RESPONSE TO PLANNING COMMENTS INCLUDING CALCULATIONS – Rev. E

SIMPLY UK

HOOK ROAD, PAGHAM

CS&P REF: 9418

DRAWING No.	REV.
Simply UK 003	P1

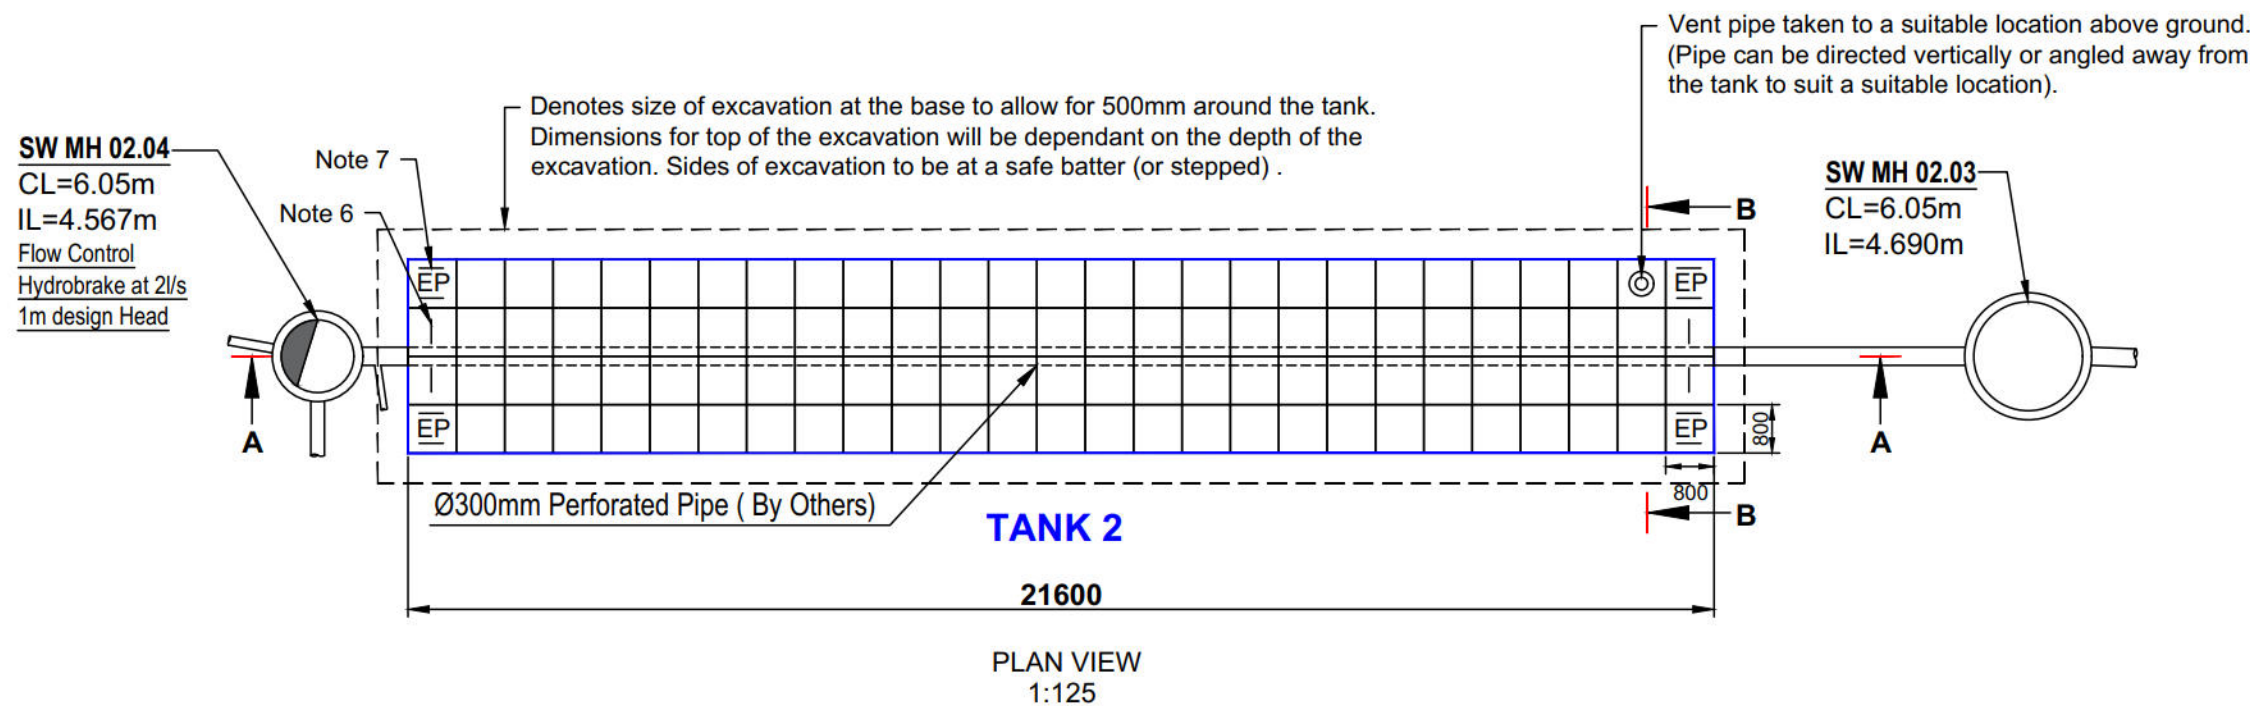
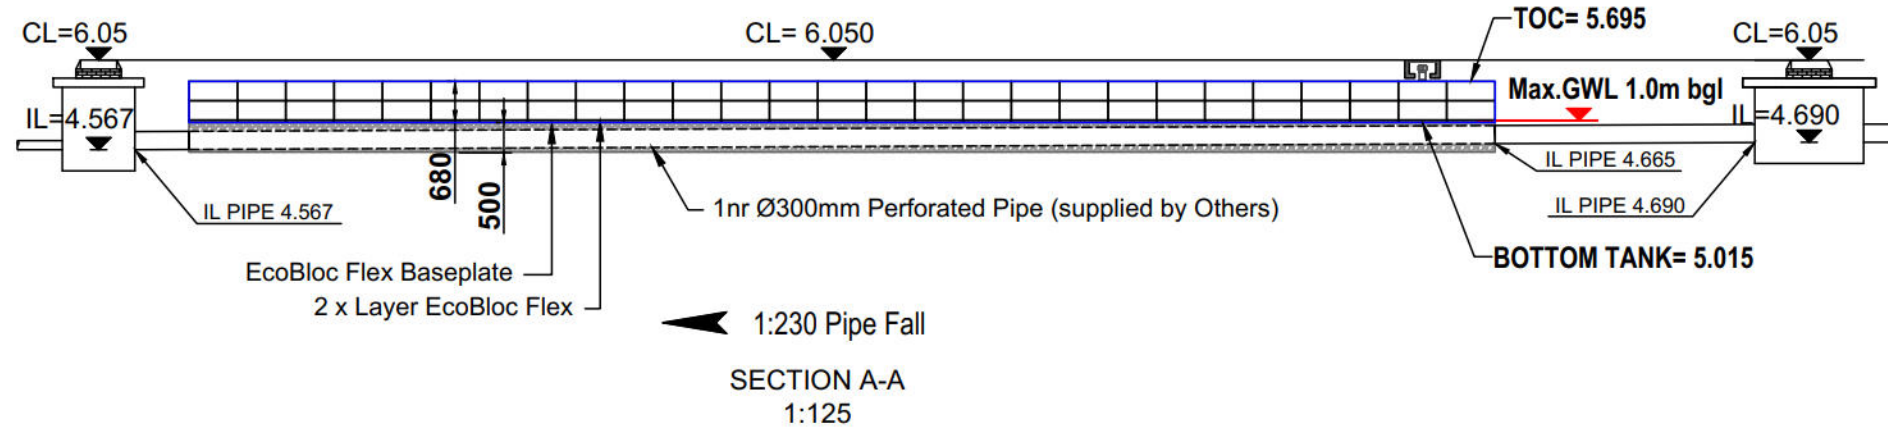
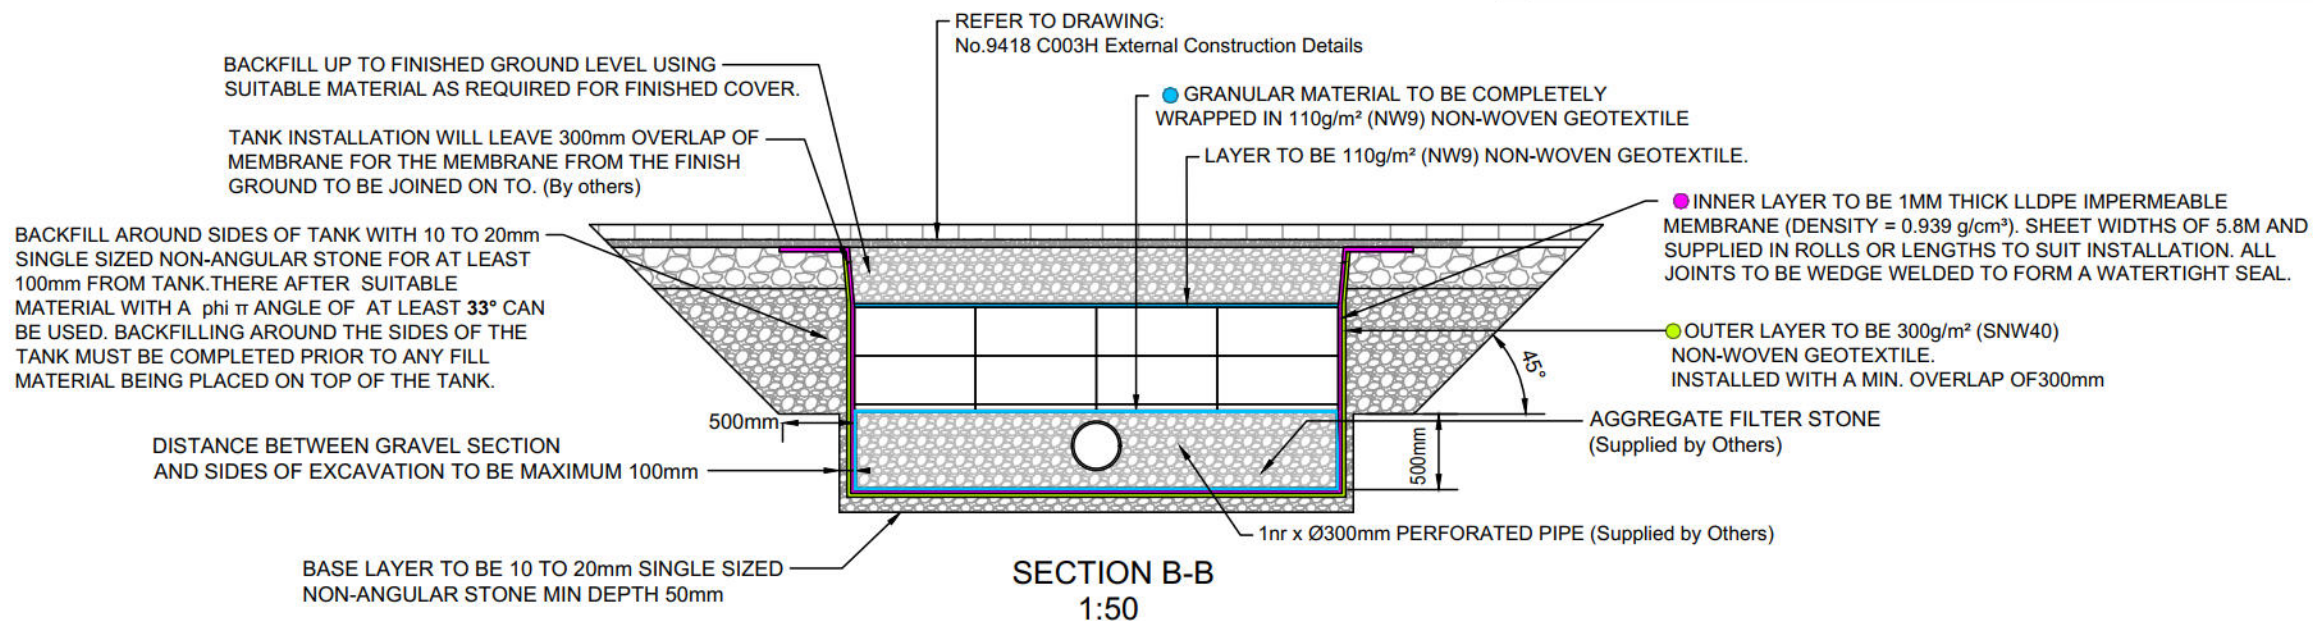
A. The tank detail on drawing 9418-C003-H still indicates conflicting information. The plan section indicates 2x 225mmdia. Or 3x150mm dia pipes whilst the section indicates a 300mm perforated distribution pipe.

E. As per comment to A.

I. The detailed design of these tanks is required to support this condition

A & E - We have provided revised drawings in Appendix F.

I - We have provided the detailed drawings in Appendix H.

Rev.	Description	Date	Initials	Checked
INFORMATION				
Client	SIMPLY UK			
Location	HOOK LANE PAGHAM, PO21 3PB			
Drawing Title	PROPOSED FORMATION LEVELS FOR CAR PARK			
Date	Drawn by	Scale	Checked	Date
NOV 25	AL	1:1	LC	NOV 25
Project Ref.	9418		Dwg. No.	C017
Rev.	1

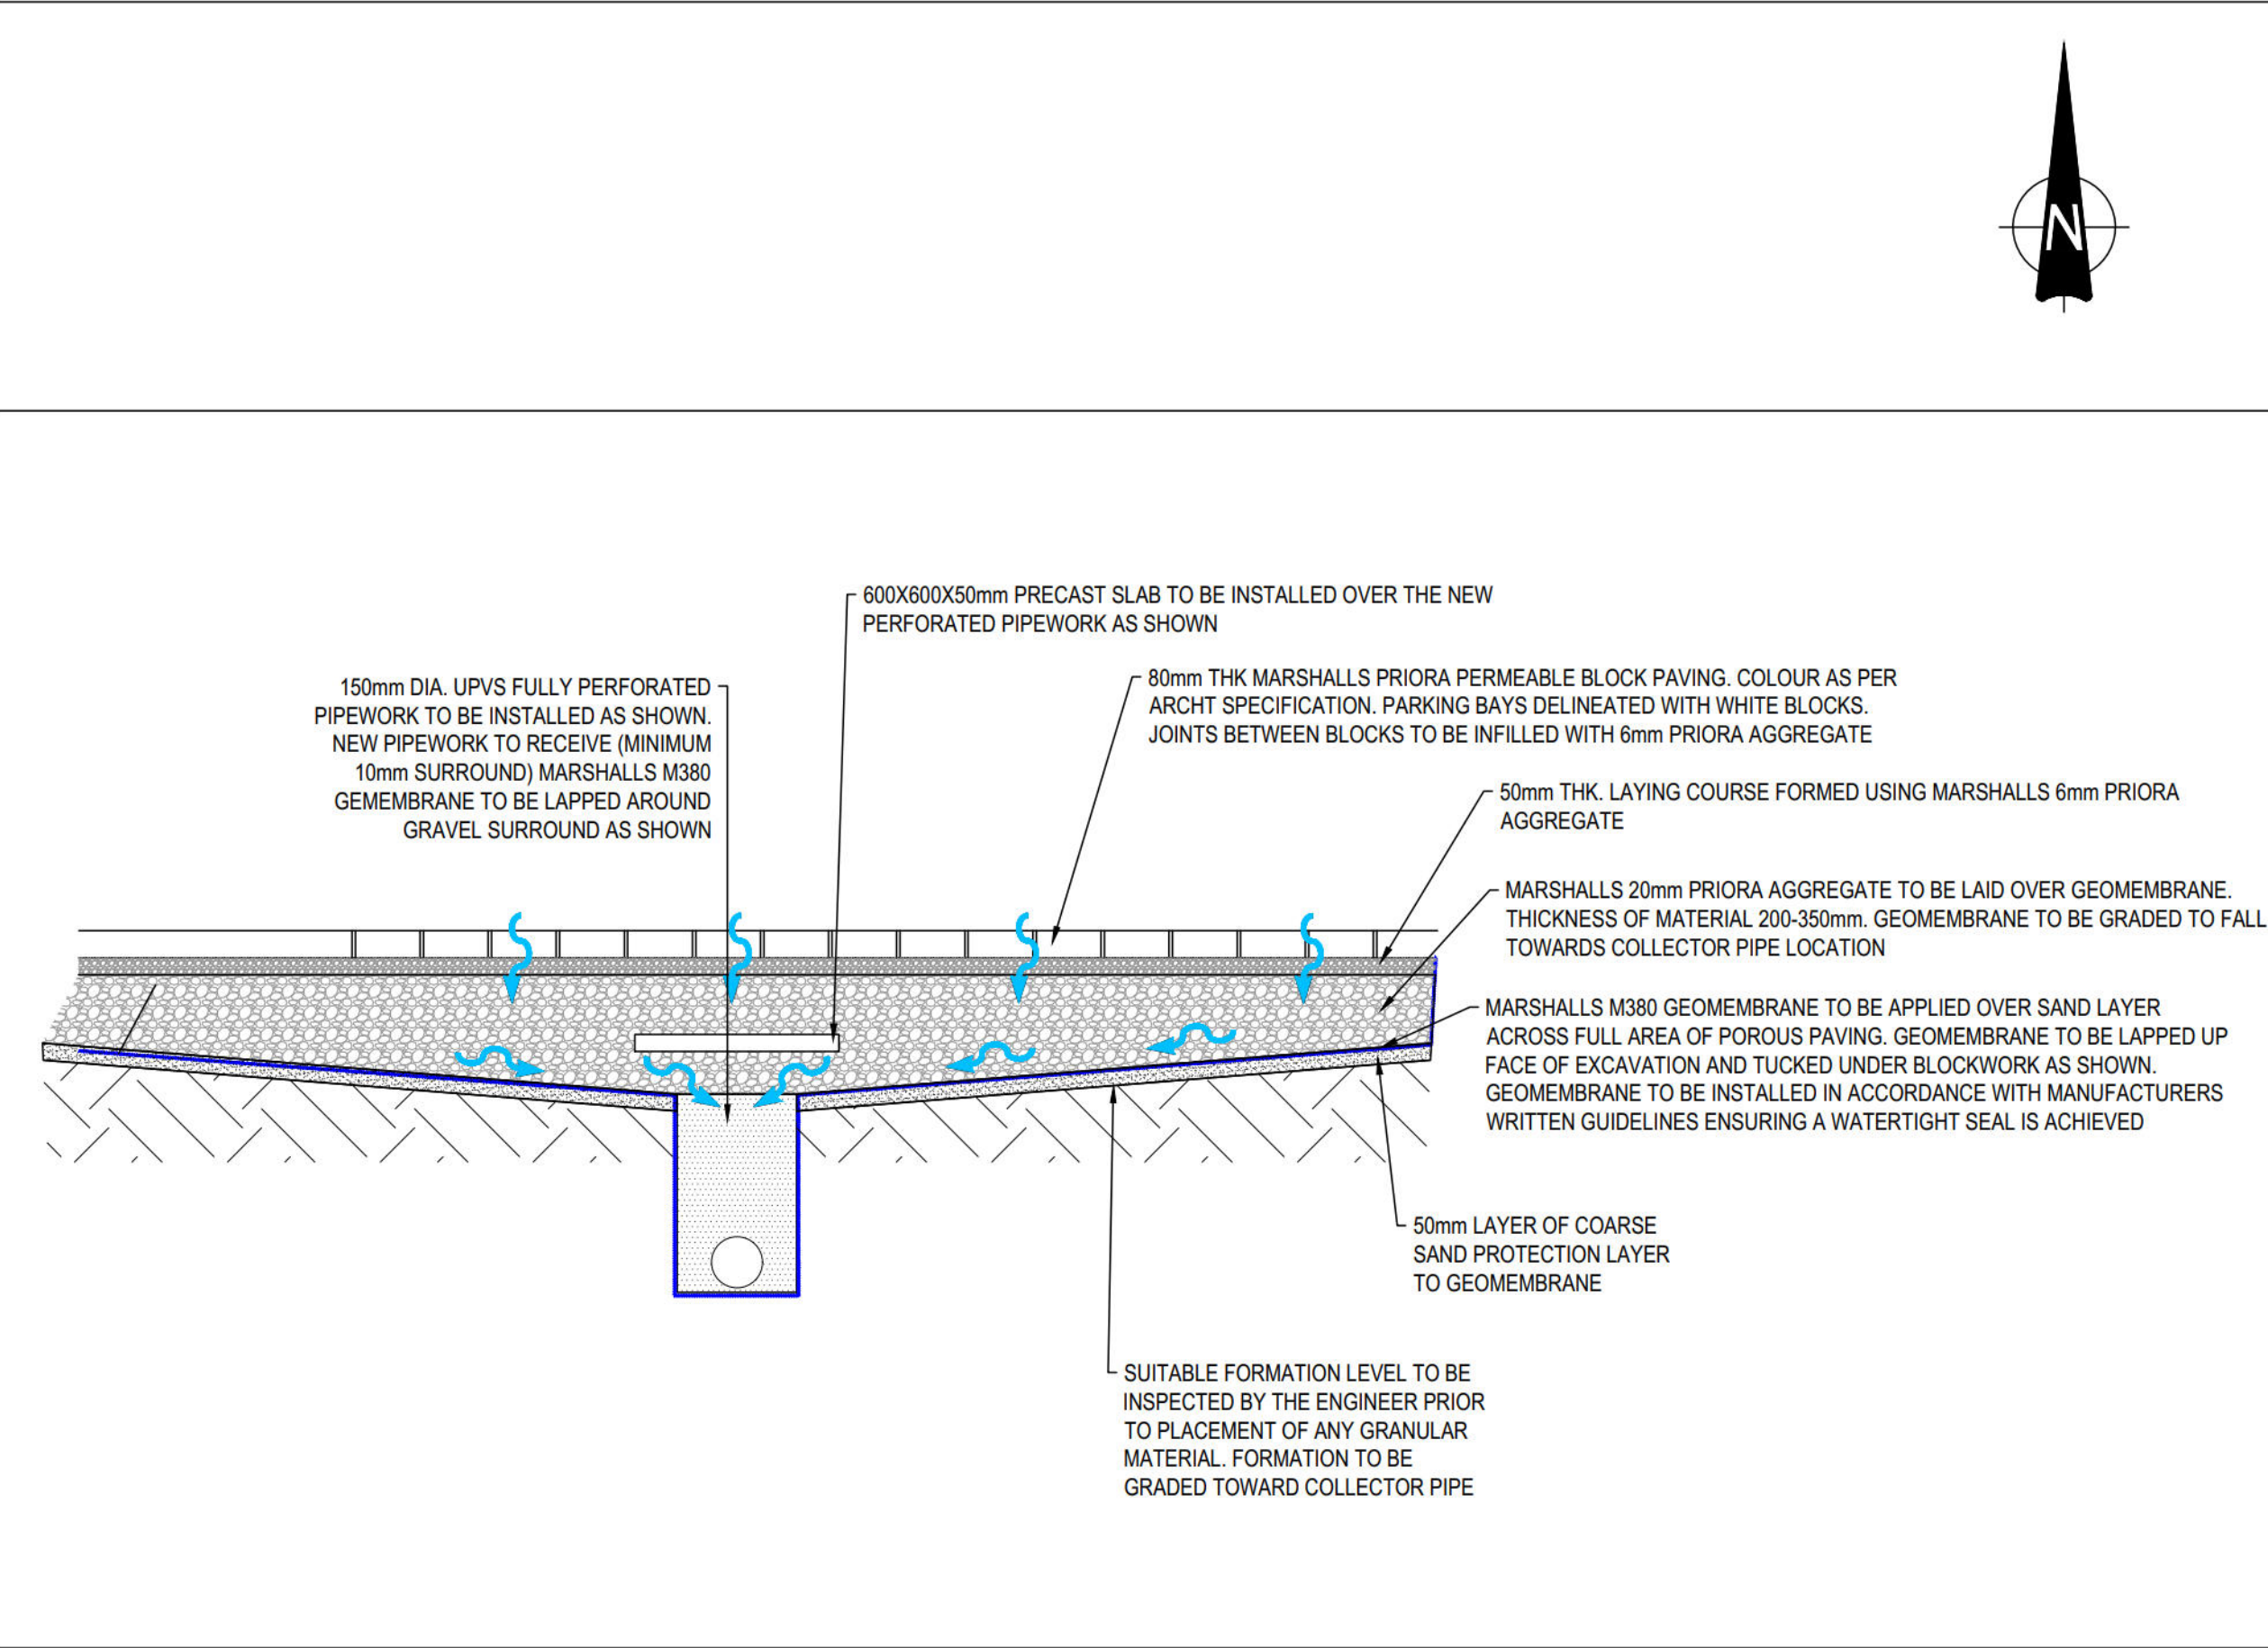
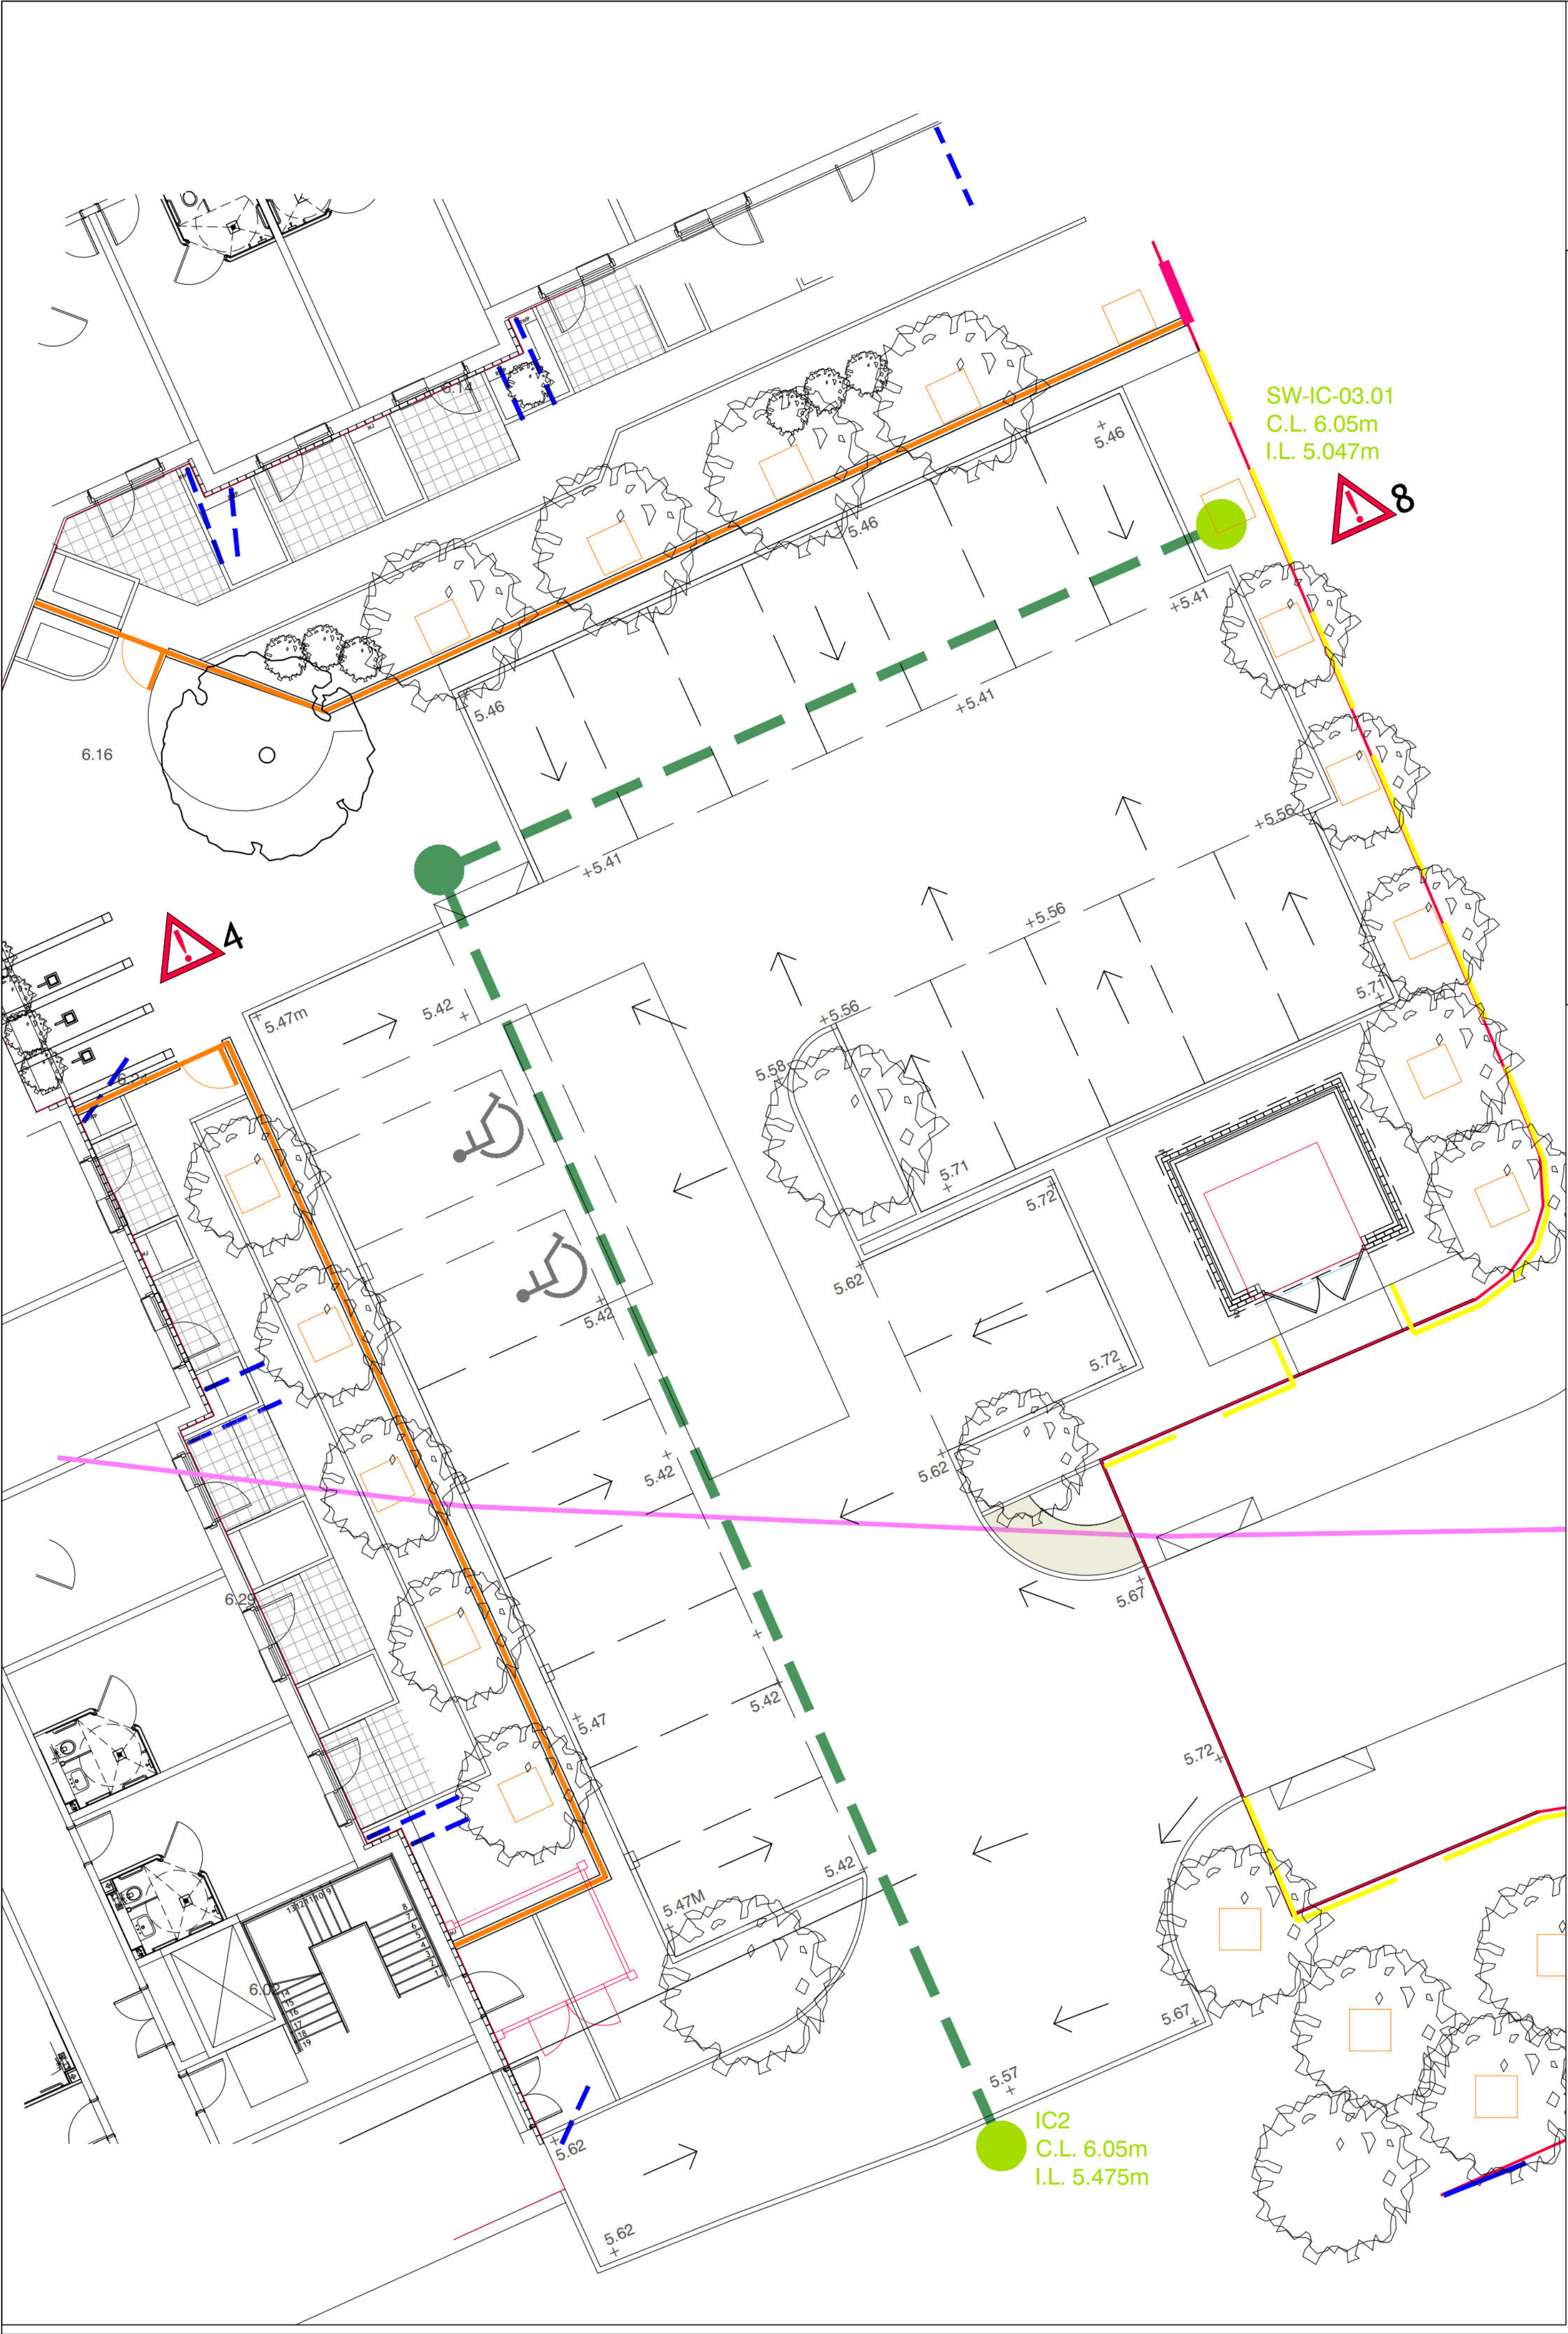
- B. Item is still outstanding please provide formation levels on plan for the permeable paving.

The minimum thickness of subbase is 300mm thick as shown on our drawings. The formation level is graded out to low points. Contractor will install pipes accordingly to suit services. We have revised a drawing to indicate the formation levels for the permeable paving in Appendix K.
